Project #: 1007776 Application #: 12DRB-70358
12DRB-70359
12DRB-70360
 Project Name: Taylor Ranch
 Agent: Precision Surveys Inc Phone #:
& Guy Jackson's Assoc.

City of Albuquerque
Planning Department
Inter-Office Memorandum

TO: Jack Cloud, DRB Chair
FROM: Randall Falkner, Planner
SUBJECT: Project # 1002776

On August 9, 2012, the Environmental Planning Commission (EPC) approved Project #1002776/12EPC 40037/40038, an amendment to a site development plan for building permit and an amendment to a sit development plan for subdivision for all or a portion of Lots Y-2A-1-A, Y-2A-1-B, Y-2A-1-C & Y-2A-1-D, located on Taylor Ranch Drive, between Homestead Circle and Sooner Trail, containing approximately 10 acres.

ARCHITECT STAMP CONSULTANT STAMP DATE:
 STATE OF NEW MEXICO
 KEVIN JUNO
 No. 1603
 11-13-12
 PROJECT NO.
 0923
 SHEET NO.
 A2.1

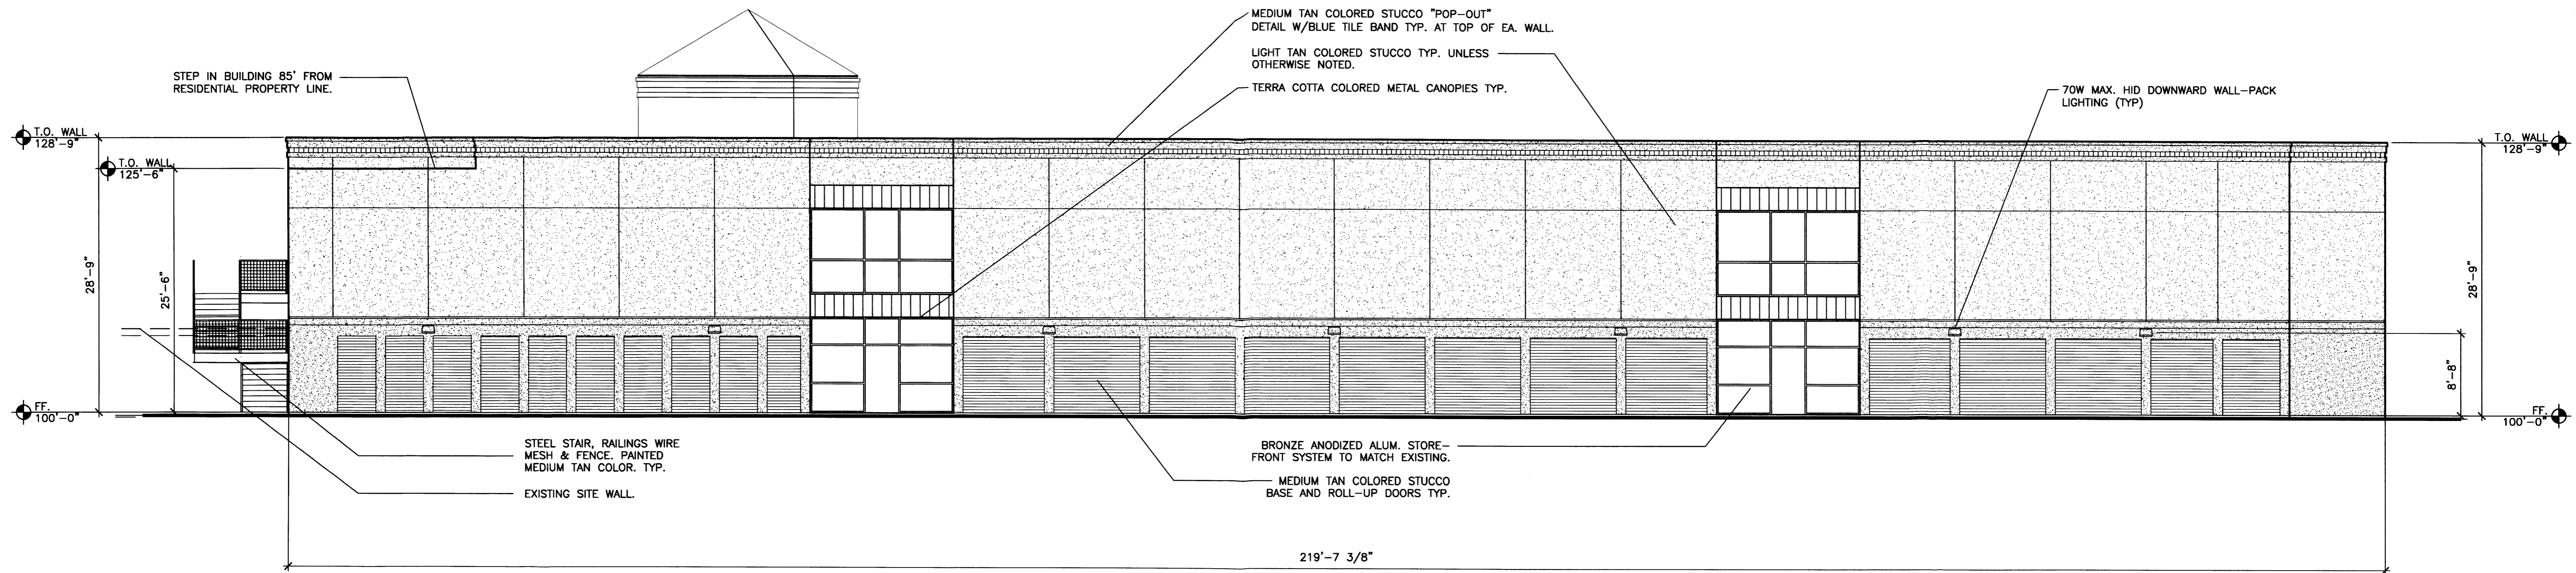
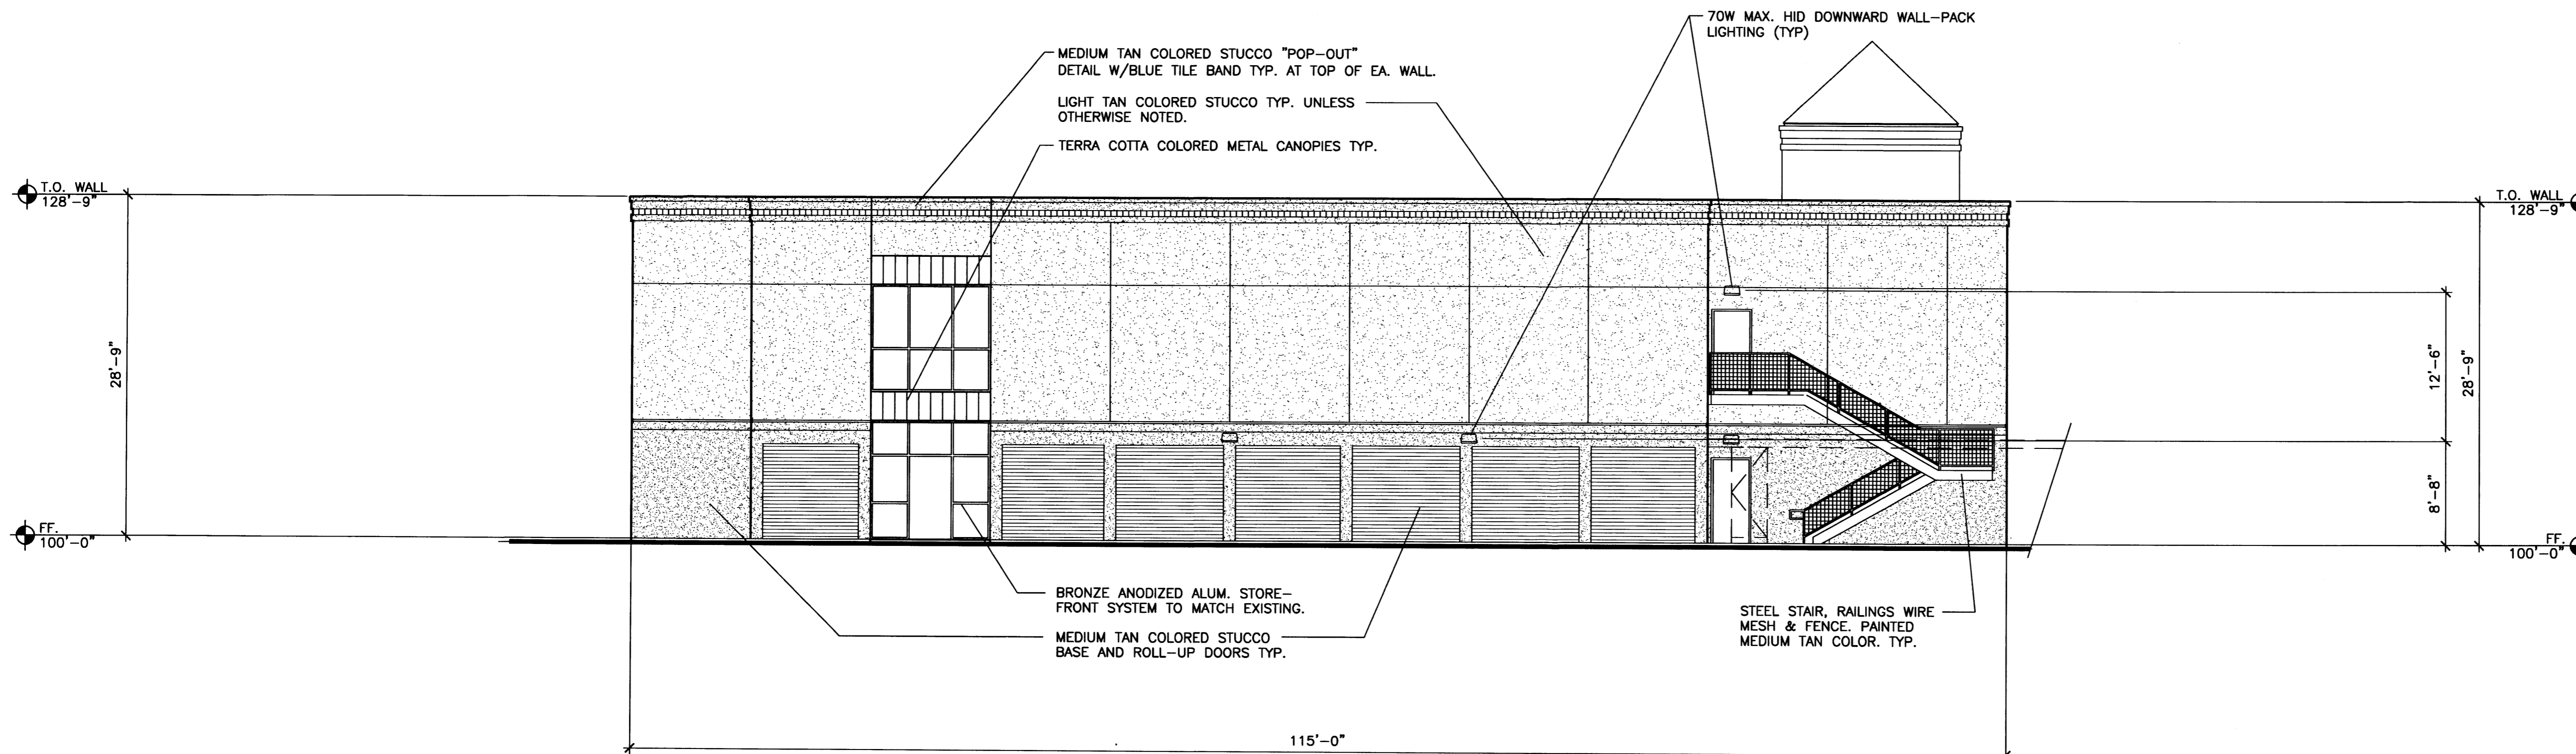
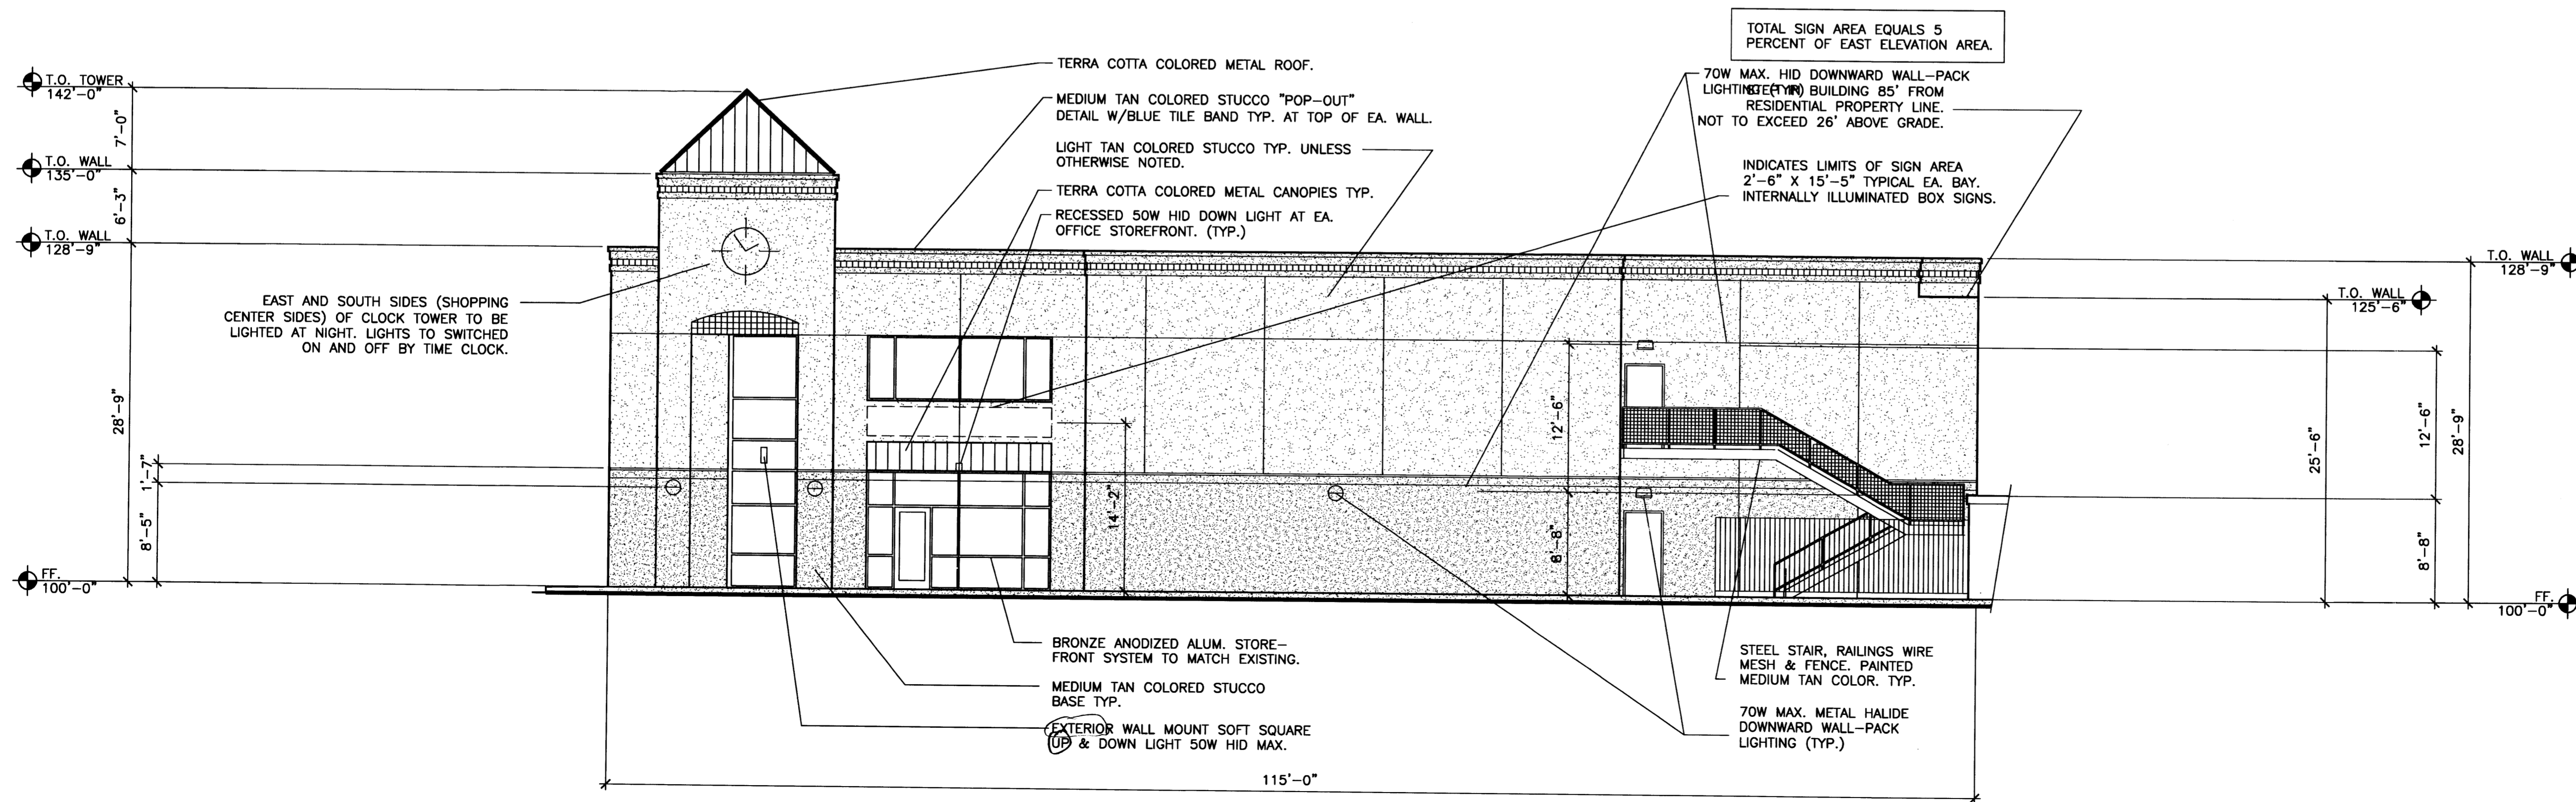
4.c. The wall pack lighting shall be downward lighting.

Explanation: The submitted site development plan for building permit elevations sheet A2.1 shows the lighting as "up and down light". Applicant has submitted a PDF that now shows the lighting as "down light". The lighting is now in compliance. A copy of the PDF has been included in the packet.
